V2_Traffic Impact Study_comments.pdf Markup Summary

TRAFFIC IMPACT STUDY

ELK VIEW ESTATES

PCD File no. SF266

APPENDIX A – Full Sized Conceptual Plan

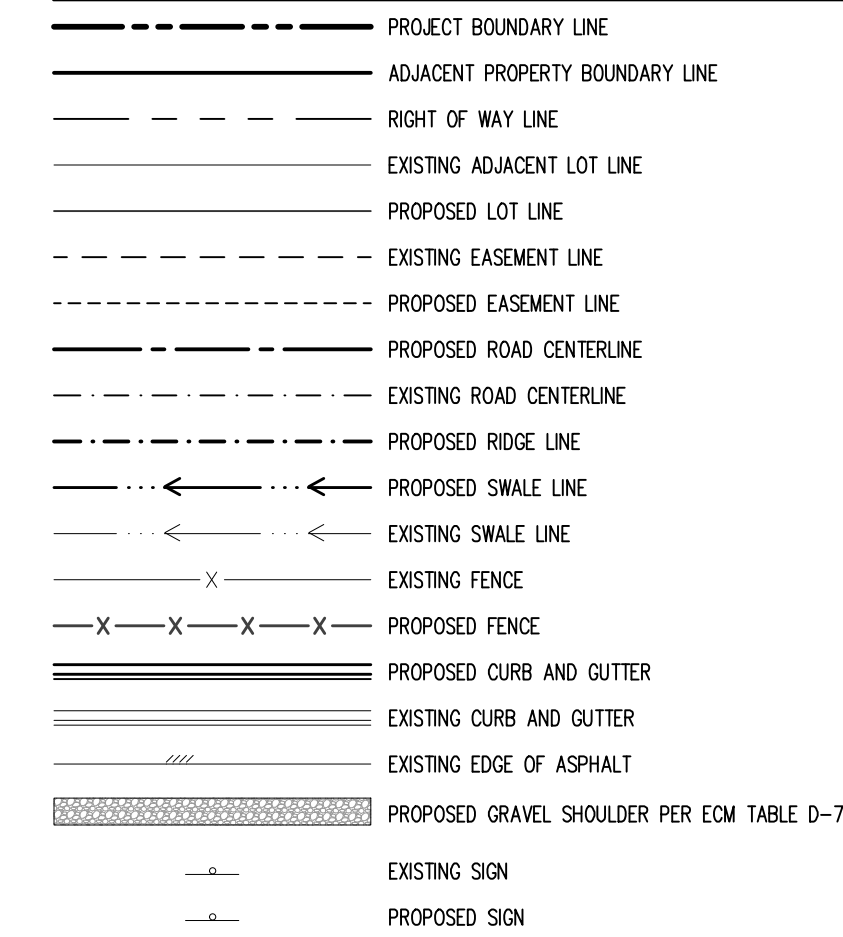
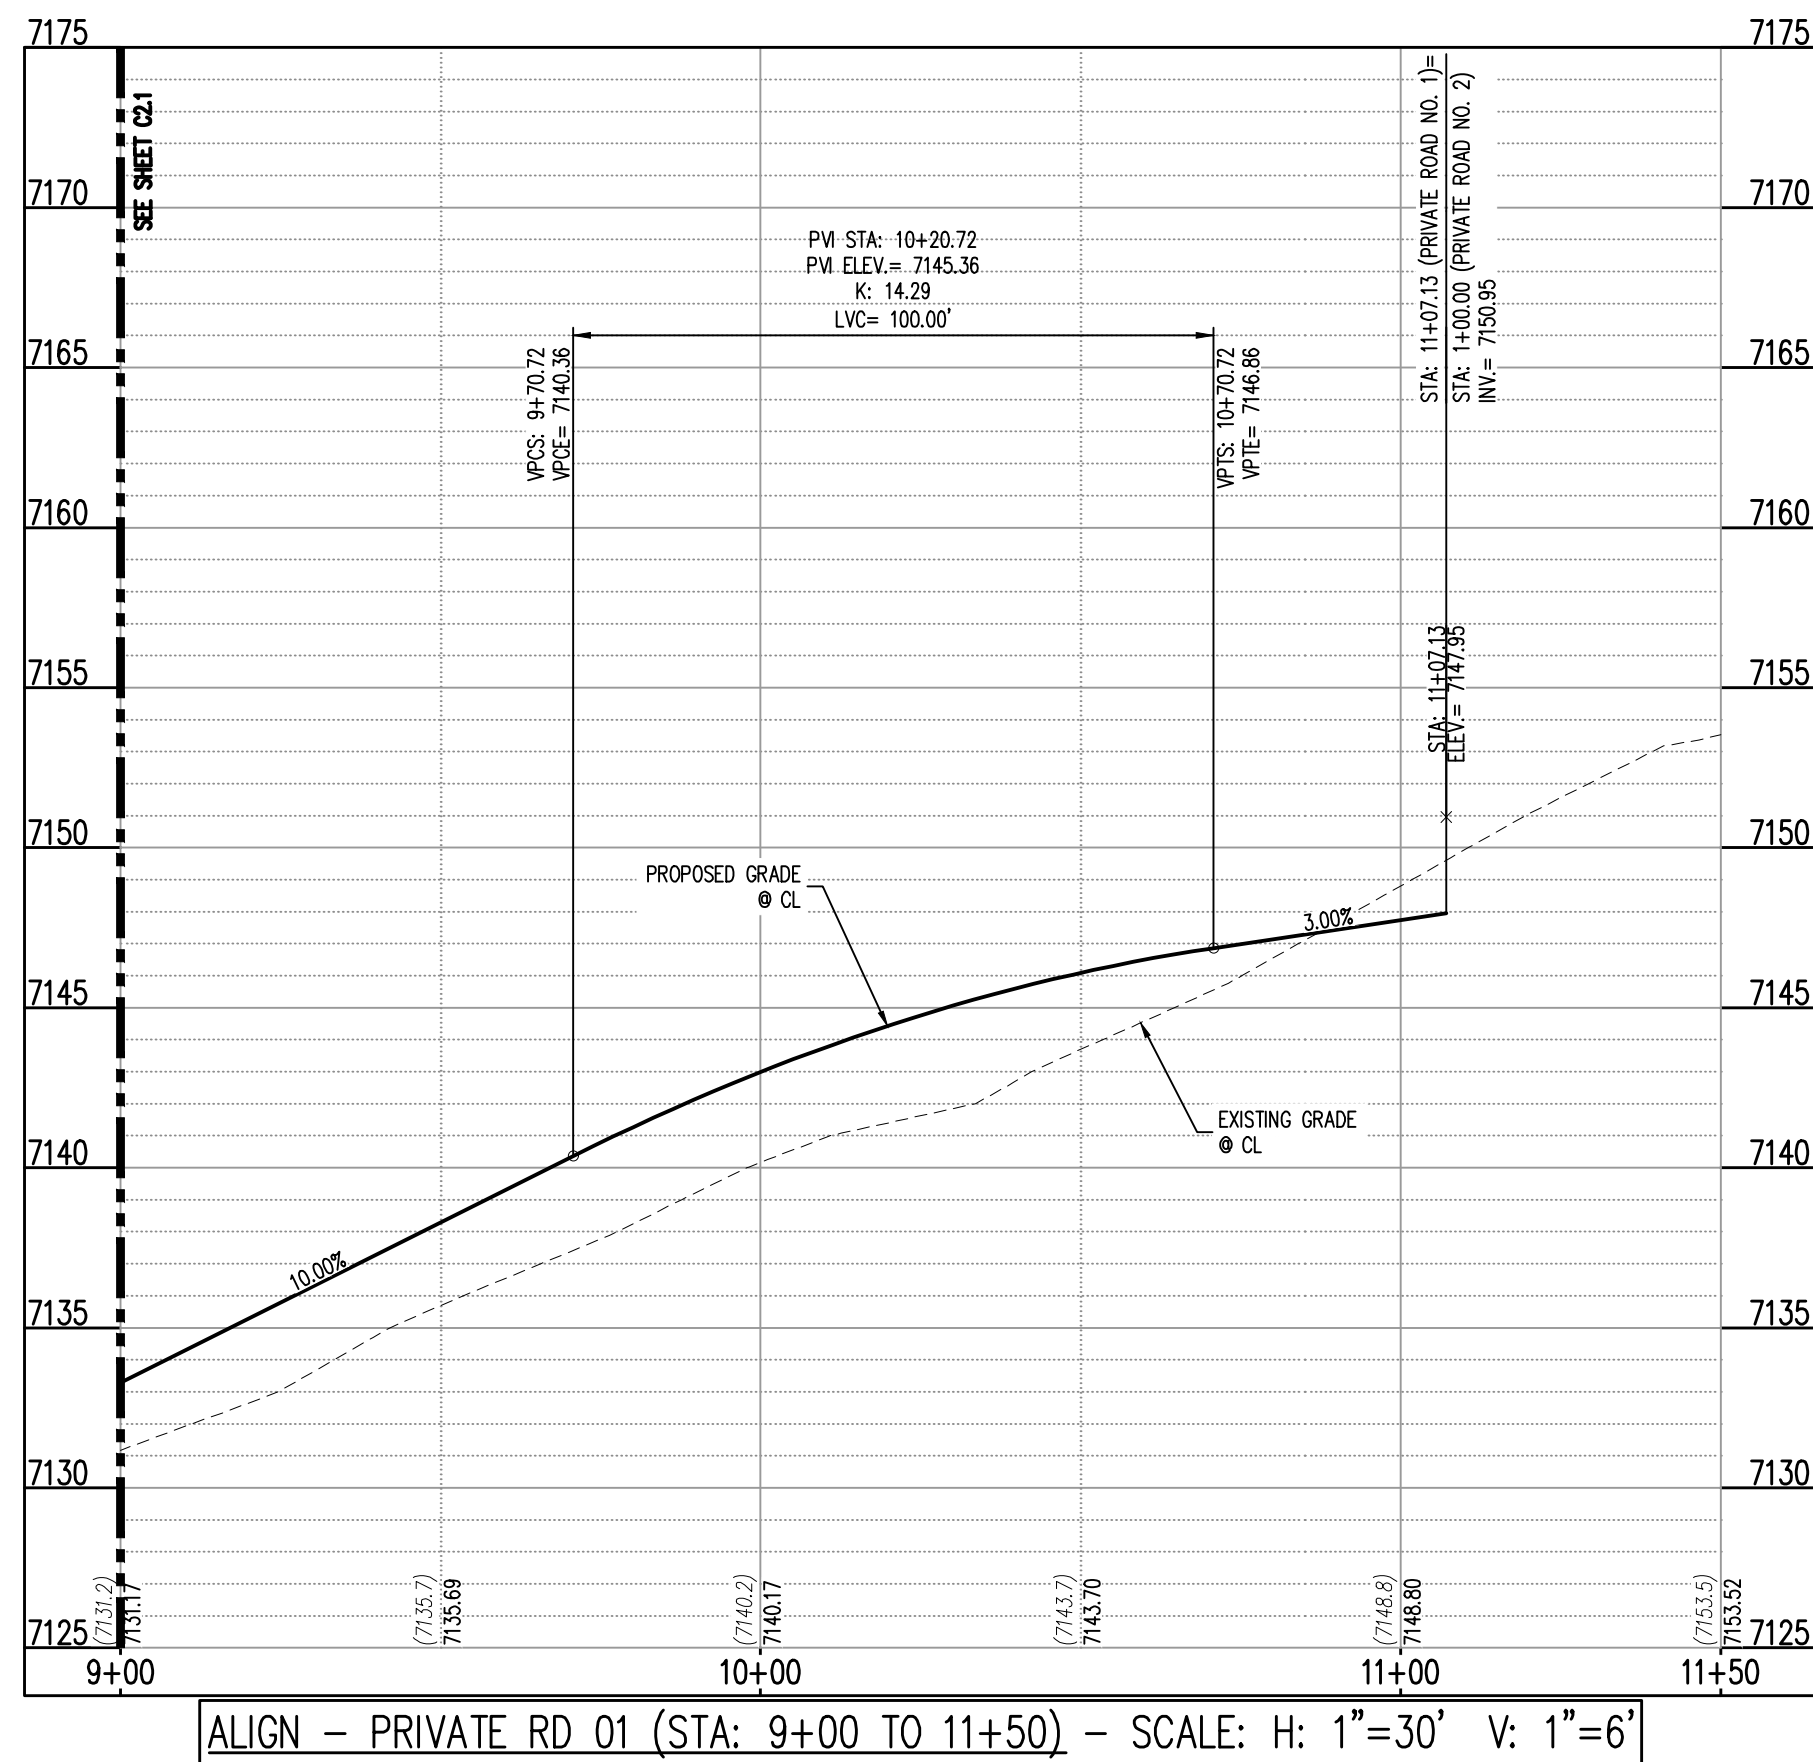
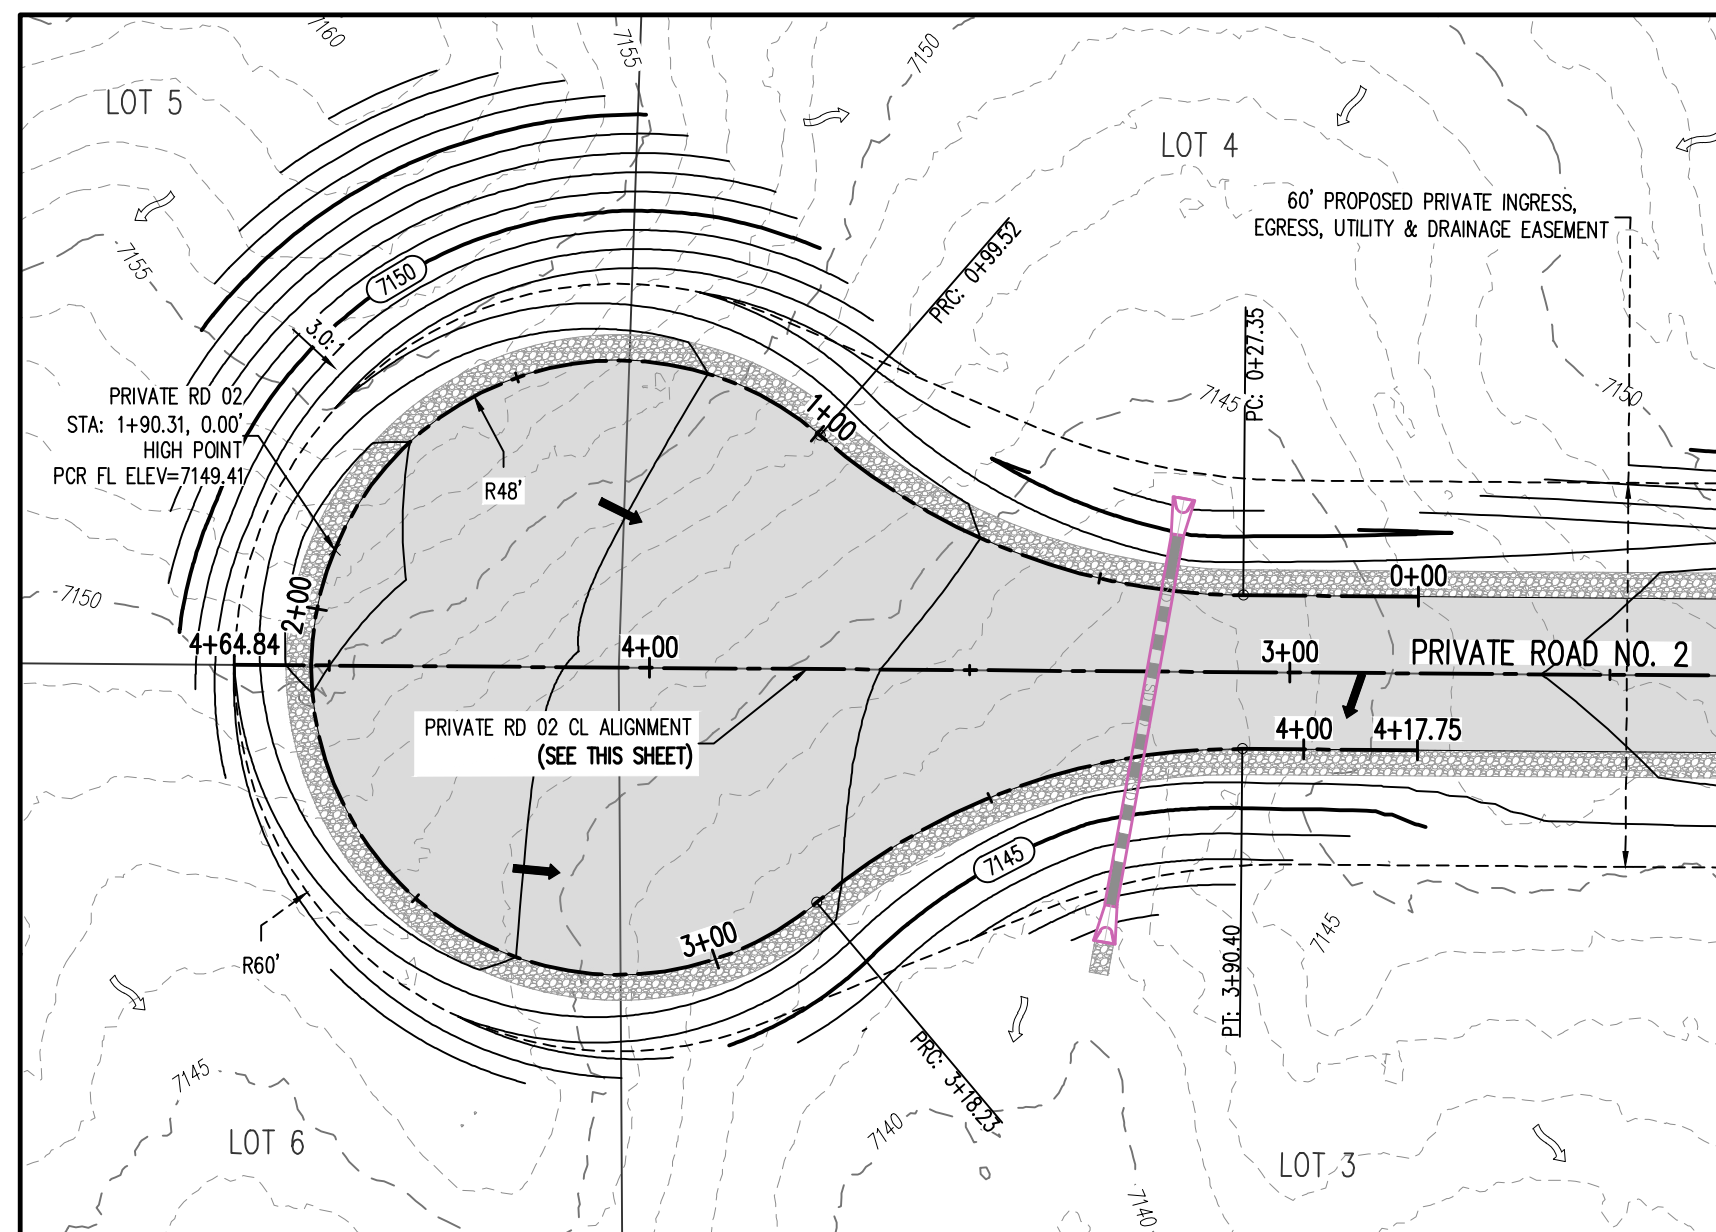
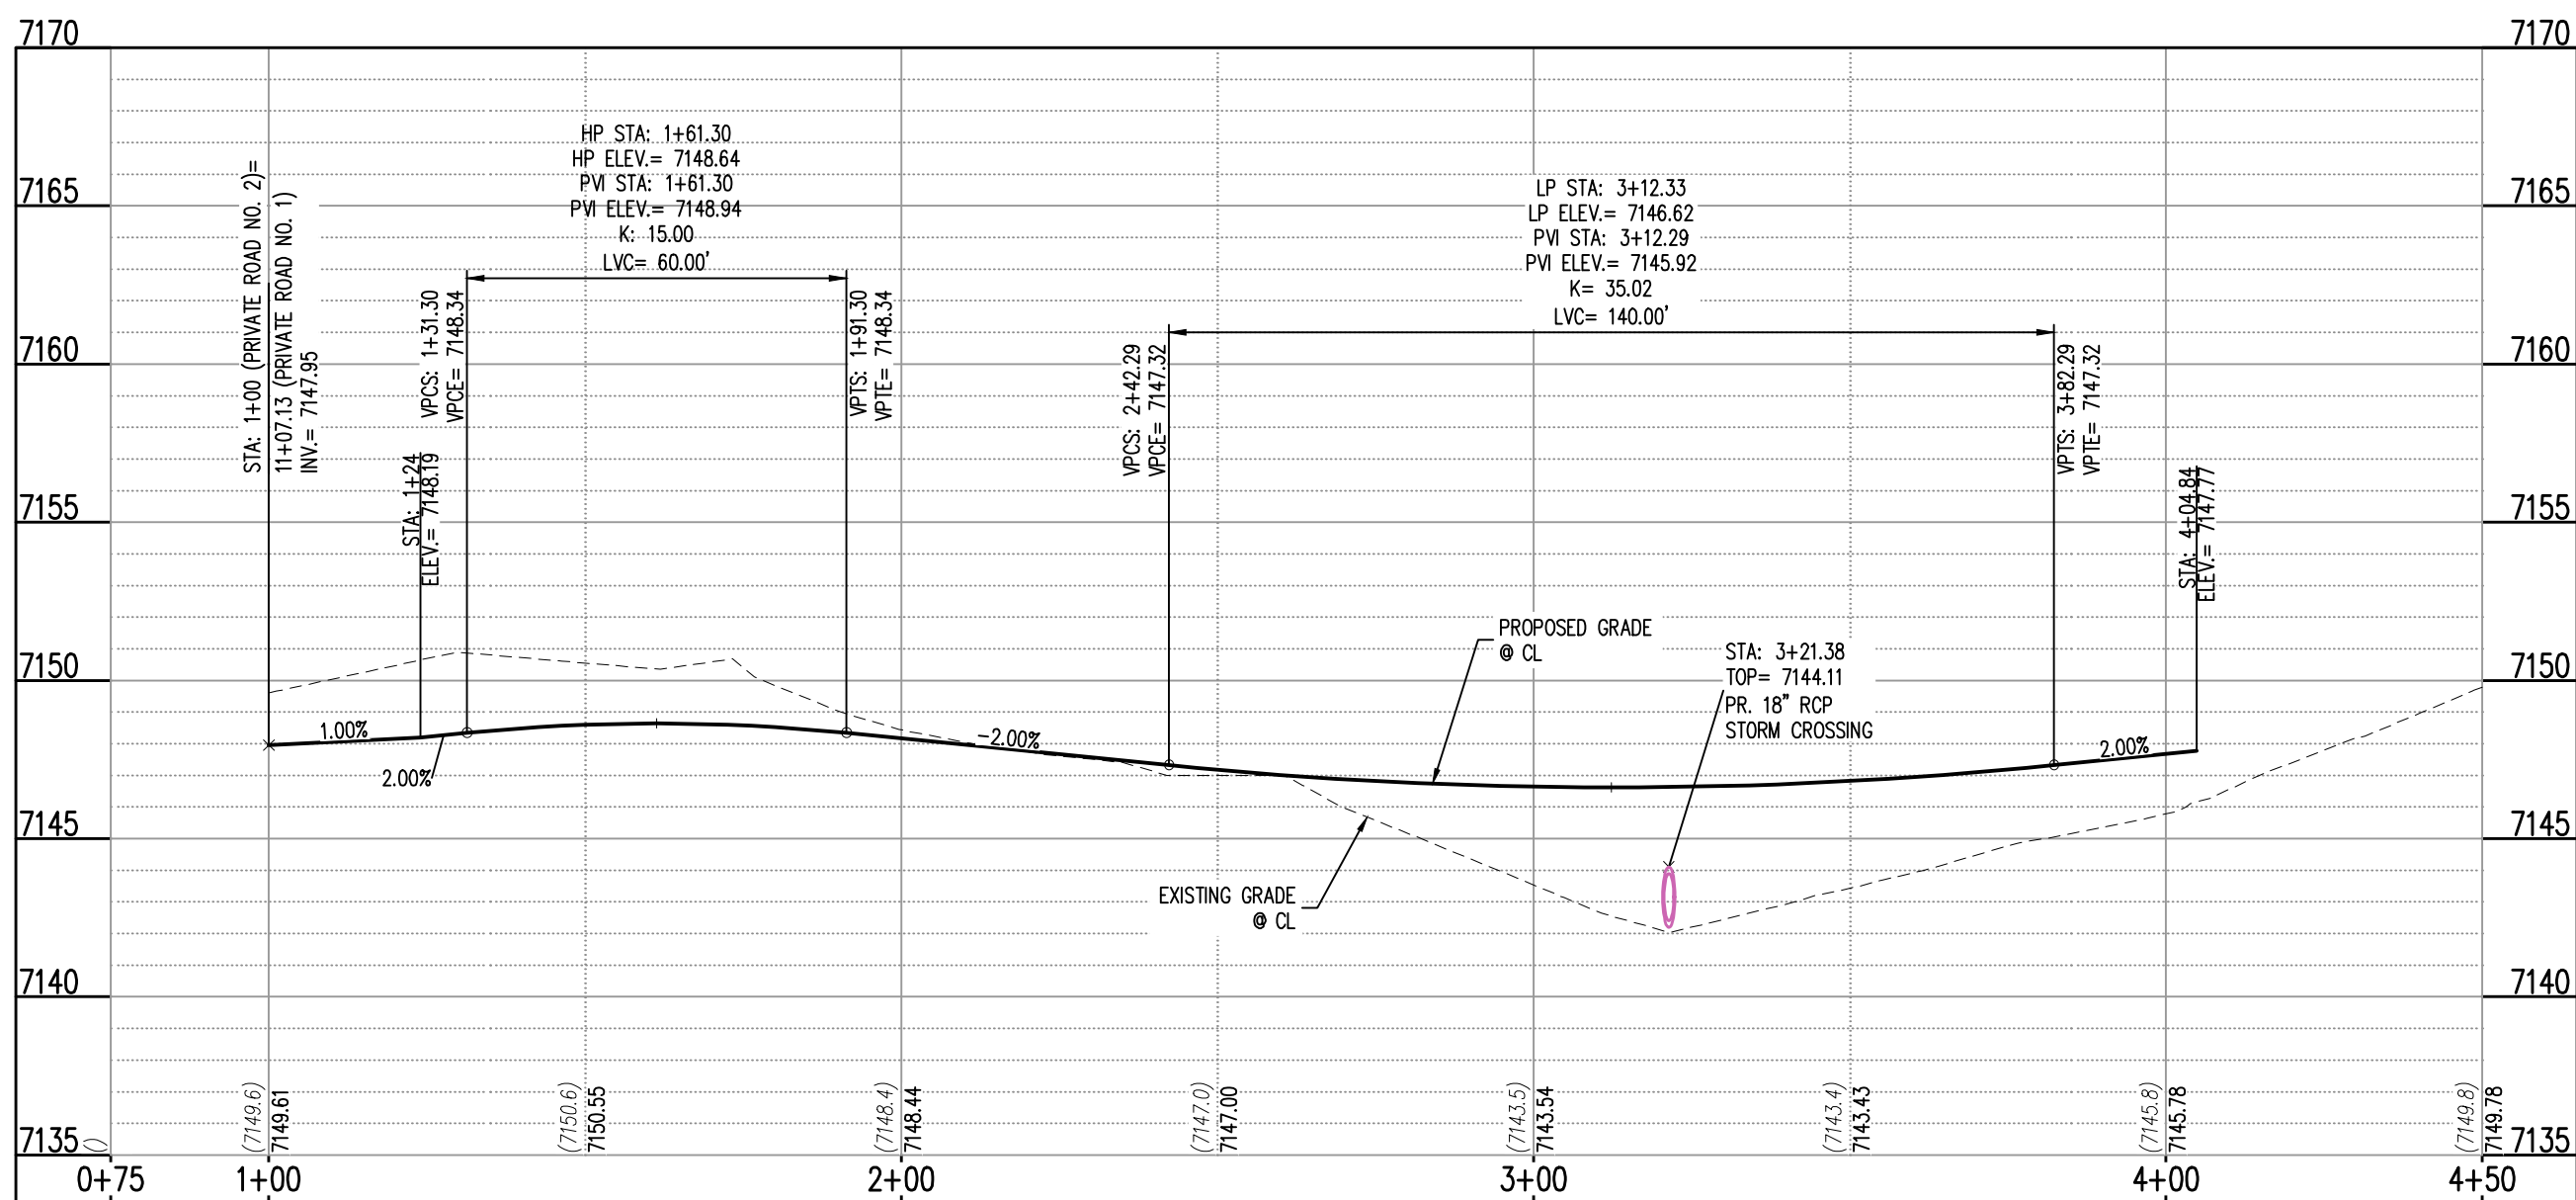
Unresolved:
Did not see site distance triangles in Appendix A.
Please provide

Unresolved:
Did not see site distance
triangles in Appendix A. Please
provide
